**Section 96A of the Town & Country Planning Act 1990 (as amended)
Town and Country Planning (Development Management Procedure) (England) Order 2015 (as amended) - Article 10**

Non-material amendment following the grant of reference BR/84/16/OUT supplemented by BR/153/17/RES for the changes to the appearance of the proposed buildings, for revised door and window design and size, and the decorative brick banding detail.

3 Southdown Road Bognor Regis PO21 2JS

PROPOSED ELEVATIONS

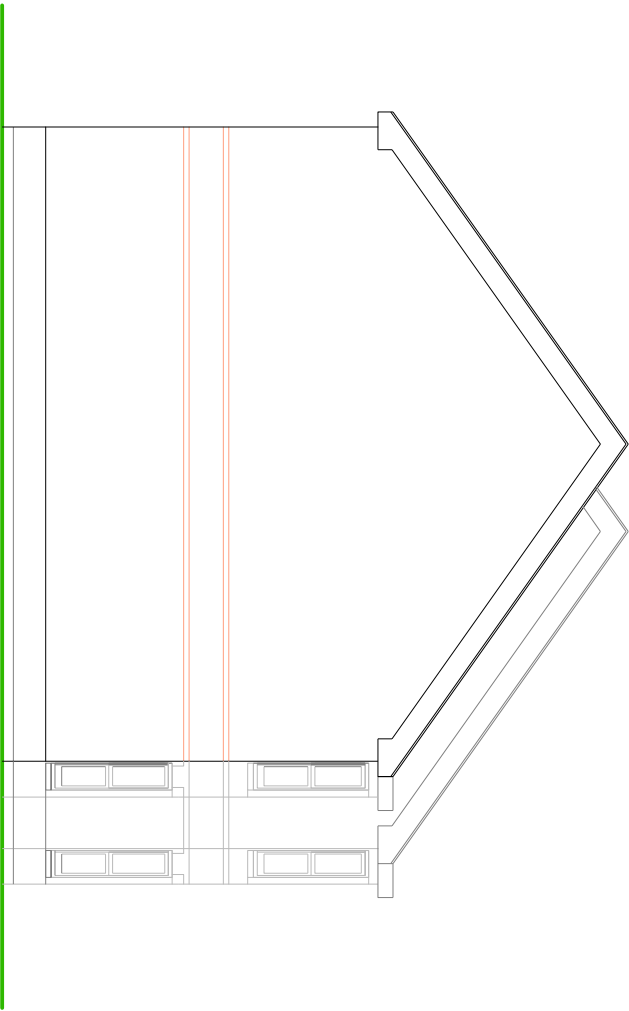
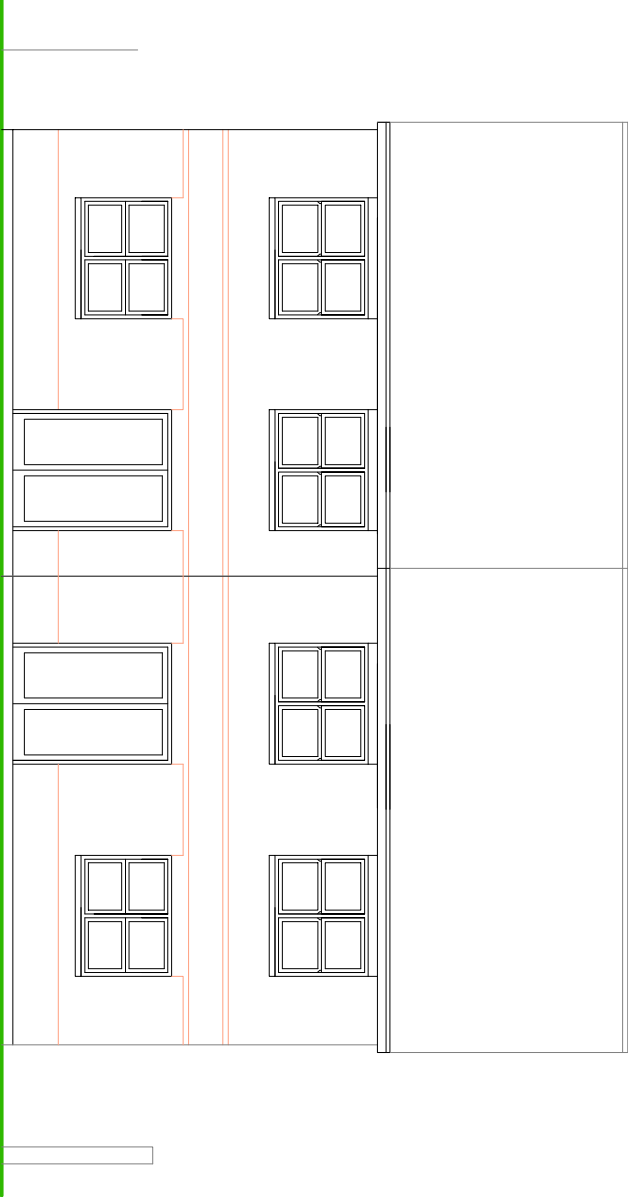
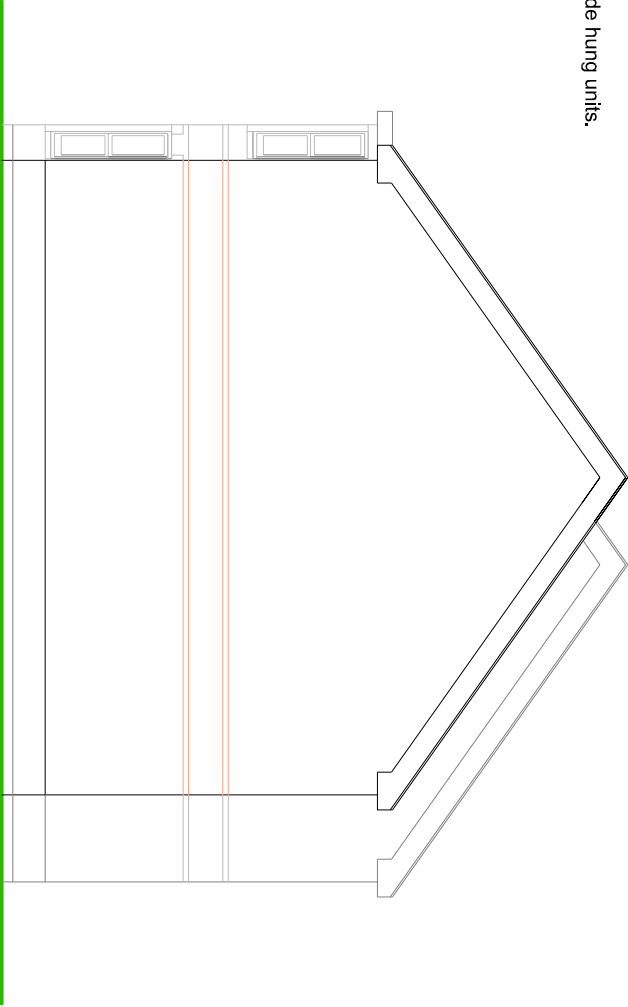
I refer to your recent application for a Non Material Minor Amendment. I note that you propose to change the appearance of the buildings by:-

- (a) revising the door and window design & size; and
- (b) revising the decorative brick banding detail.

Please note that the drawing 3SR/SBCL/01 Rev A "Proposed Elevations" replaces those elevations shown on drawing DPA-01 Rev 01 "Proposed Location, Site, Floor Plans and Elevations".
